## City of Albuquerque Stormwater Construction Site Inspection Report

General Information					
ESC File No.	K09E051	Project Name:	Titan (Spec) 150K		
NPDES Id. No.	NMR1004R6	Location:	Daytona and Bluewater Rd		
7/12/2023	Owner	Contractor			
Operator	Westpoint 40, LLC	Wilger Construction			
Contact name & title	Brian Patterson	Tim Lindgren			
e-mail	<a href="mailto:bpatterson@titan-development.com">bpatterson@titan-development.com</a>	<a href="mailto:tlindgren@wilger.com">tlindgren@wilger.com</a>			
Contact Phone #	505-998-0163	505-239-0246			
COA Inspector	Chancellor English	Start/End Time:	10am		
Construction Phase:	Paving, landscaping, interior				
Type of Inspection:	Regular	Storm Event	Post Storm Event >0.25"	311/Complaint	Follow Up
Weather at time of inspection?	Clear		Temperature: ~	95	
Estimated date of last storm 0.25" or greater	5/22/2023

SEDIMENTATION/SILT FENCE WITH WIRE SUPPORT (SF)

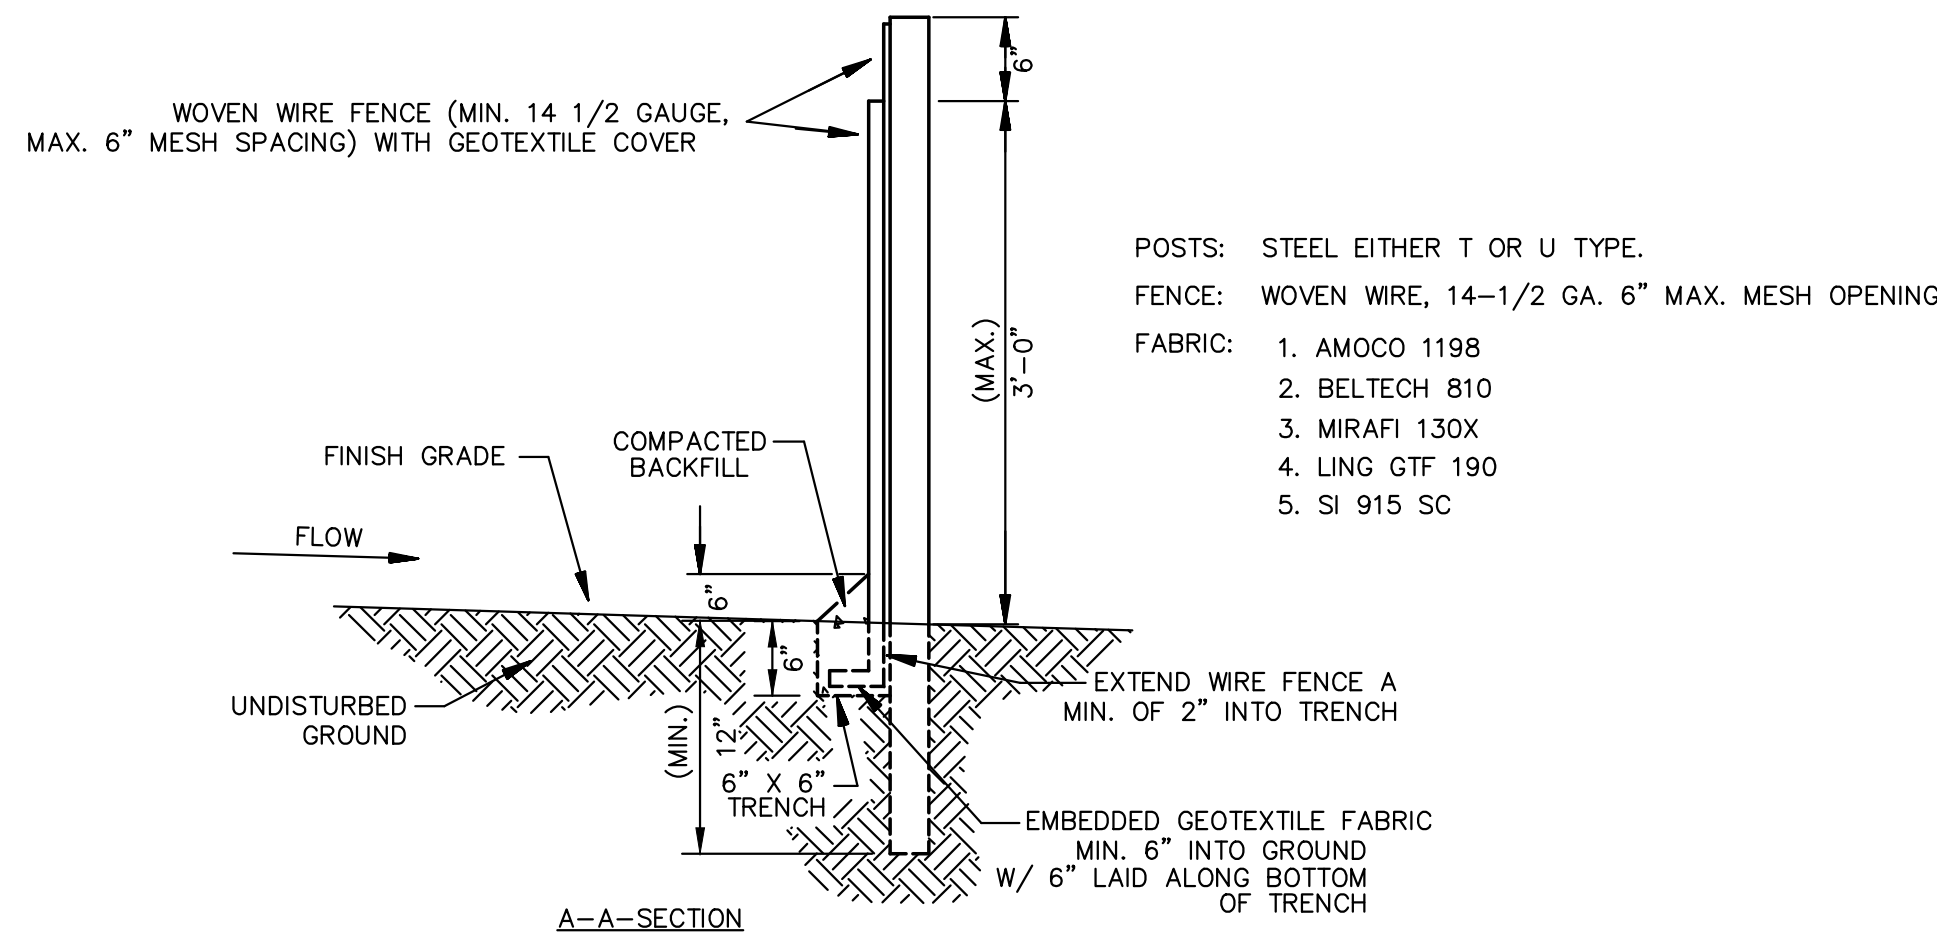
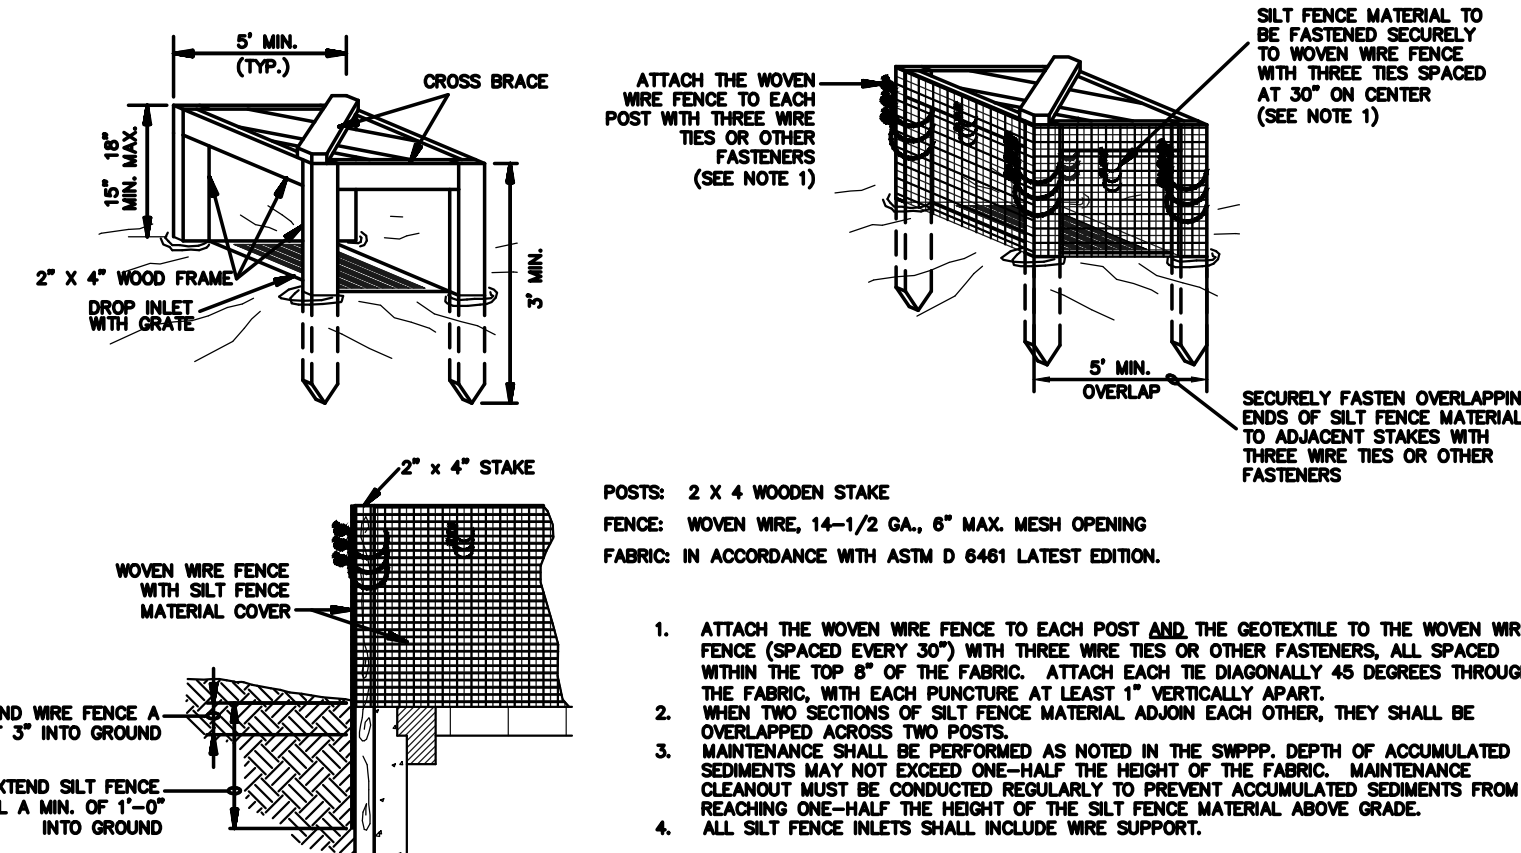
2	BMPs were damaged or collapsed. Multiple sections of the perimeter silt fence on the west and south edges of the properties need maintenance and/or repair. Required mitigation: You must ensure all stormwater controls are maintained and remain in effective operating condition during permit coverage and are protected from activities that would reduce their effectiveness per CGP 2.1.4.				
3	There is sediment discharge originating at a dirt ramp that has been recently installed on the southwestern corner of the Aspen and Autumn, LLC property that exits onto Bluewater Road. The track-out has caused a significant sediment trail along the curb of said road. Required mitigation: You must restrict vehicle use to properly designated exit points, use appropriate stabilization techniques at all points that exit onto paved roads, implement additional track-out controls to ensure that sediment removal occurs prior to vehicle exit, and remove, by proper measures, the deposited sediment by the end of the same business day, or next business day if occurring during on a non-business day per CGP 2.2.4.
